**REQUEST**

Current Zoning: ML-2 (Manufacturing & Logistics – 2)  
 Proposed Zoning: NC(CD) (Neighborhood Center, conditional)

Approximately 1.53 acres located on the north and south side of 28th Street and the east side of North Church Street, west of North Tryon Street.

## PLANNING STAFF REVIEW

**SCHEMATIC  
SITE PLAN**

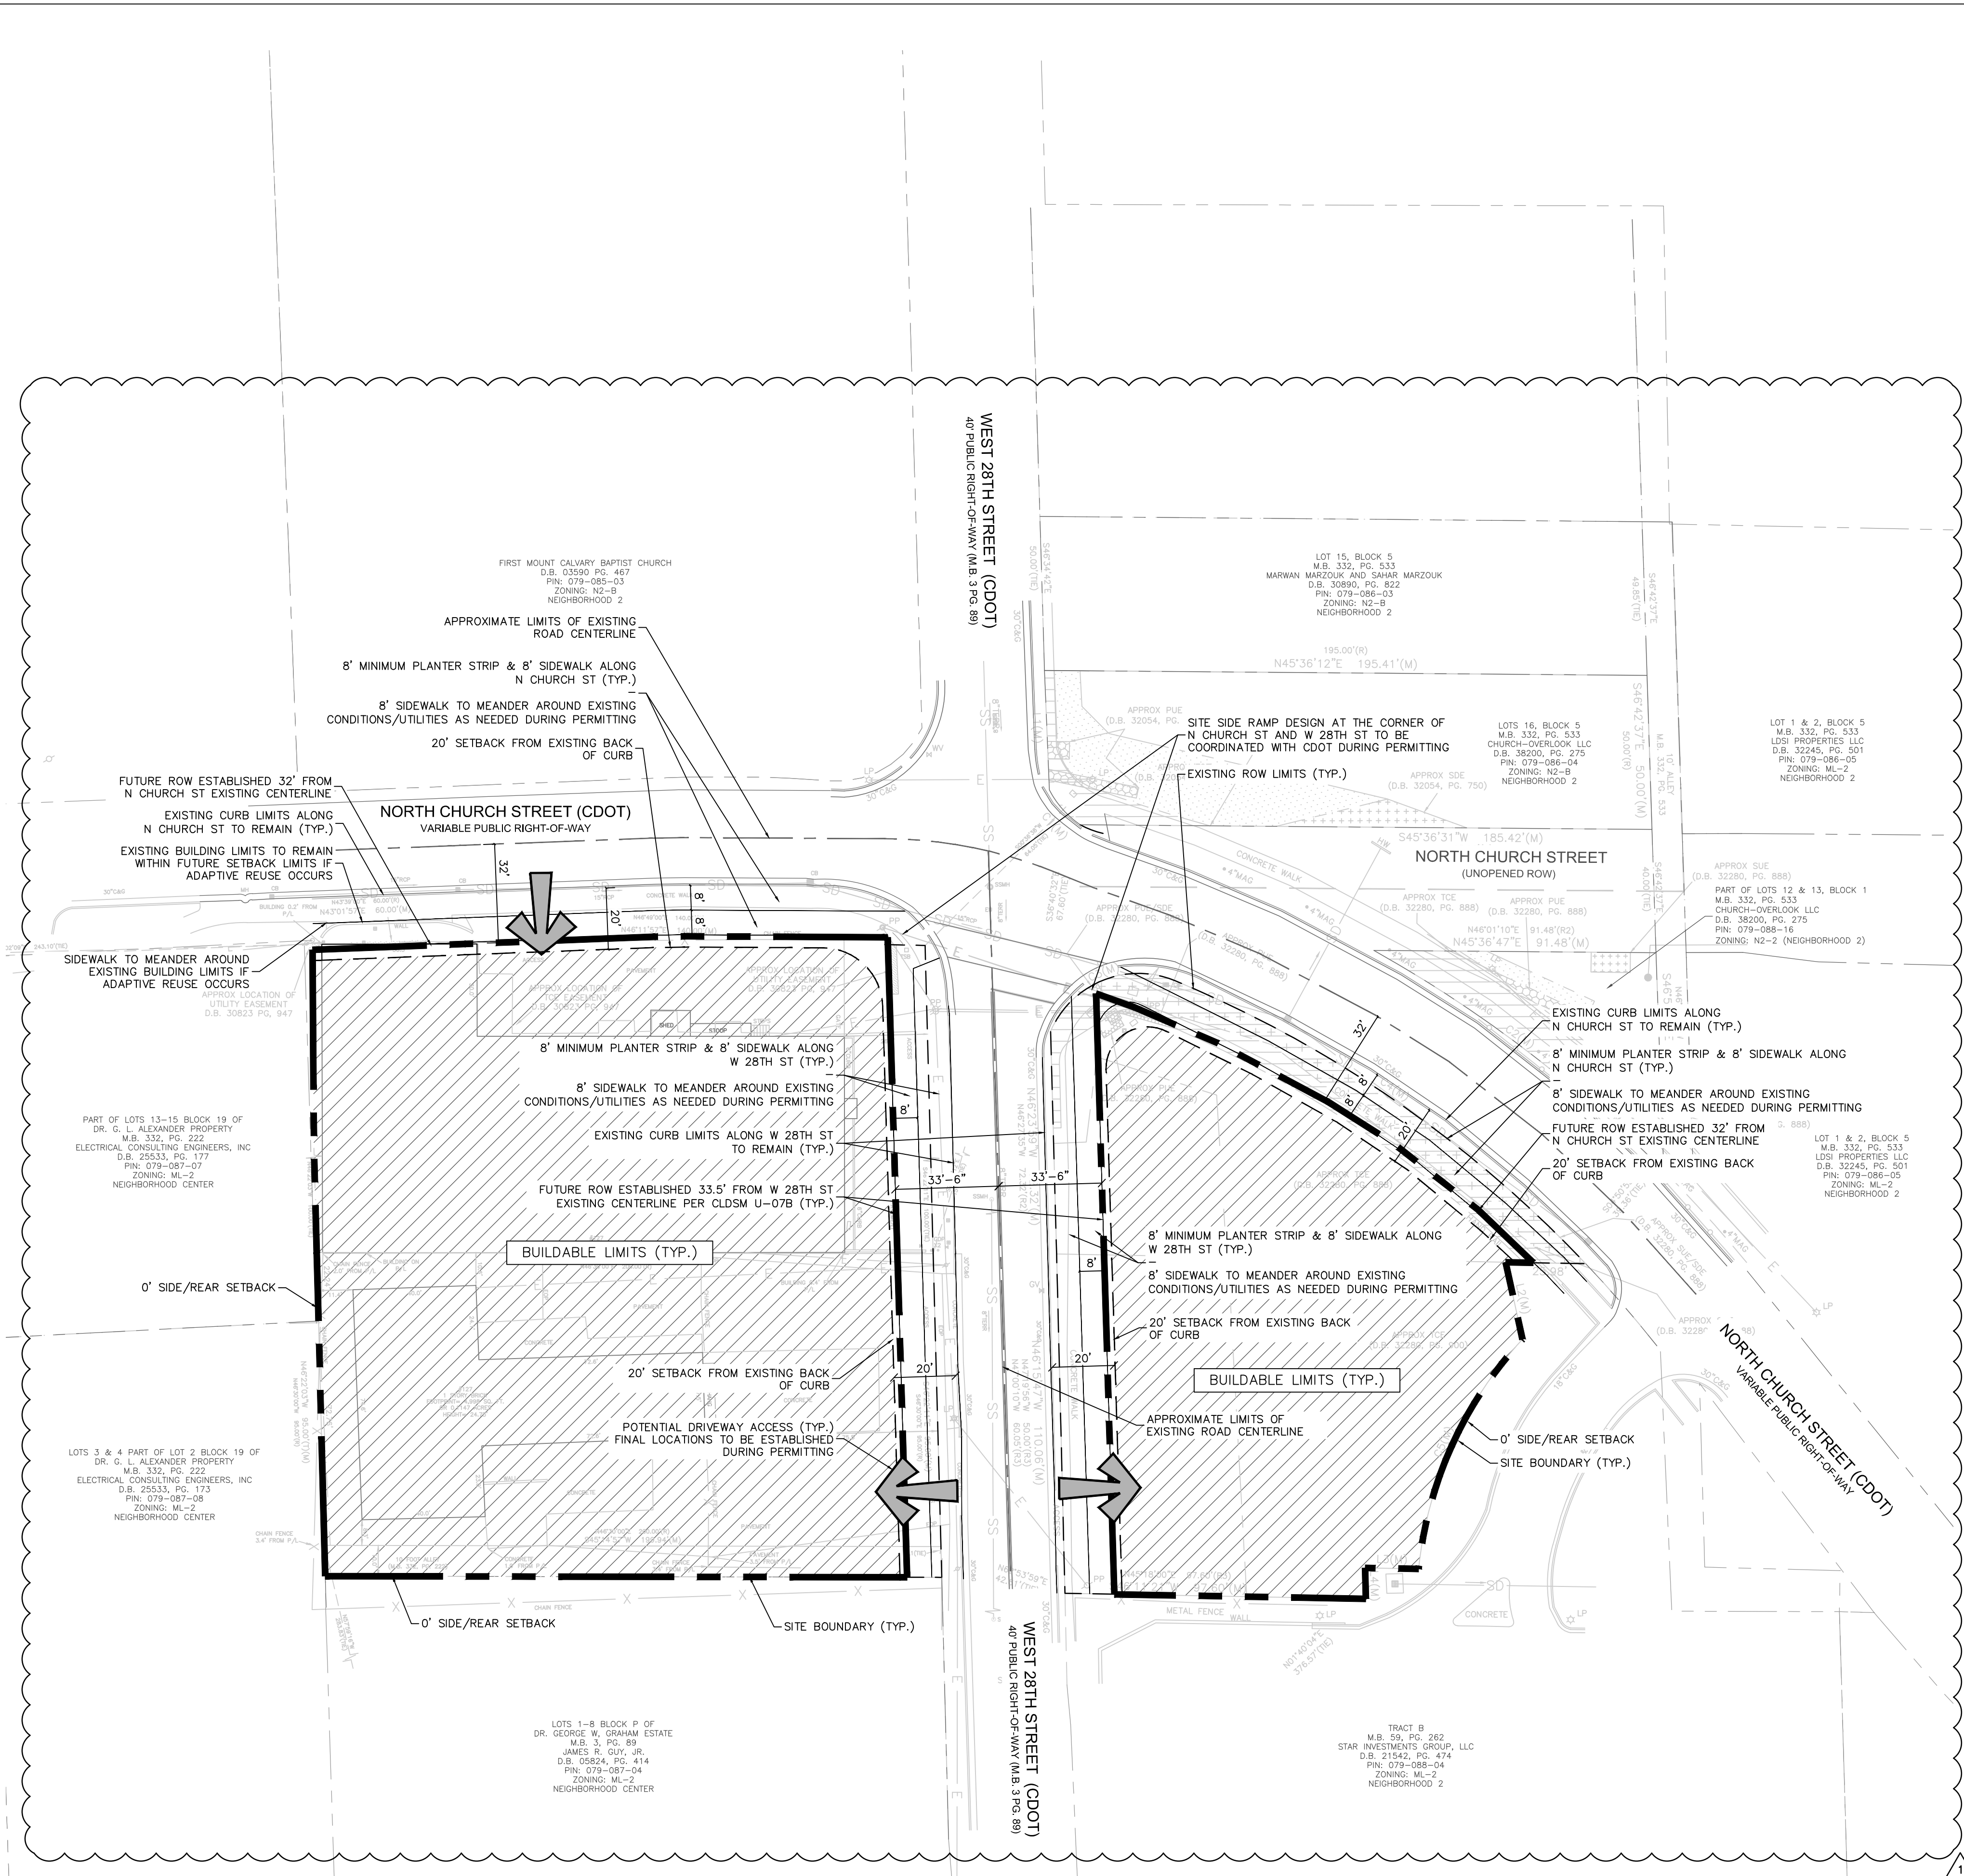
~~2. Revise the vicinity map to match the rezoning boundary of the four parcels.~~ **Addressed**
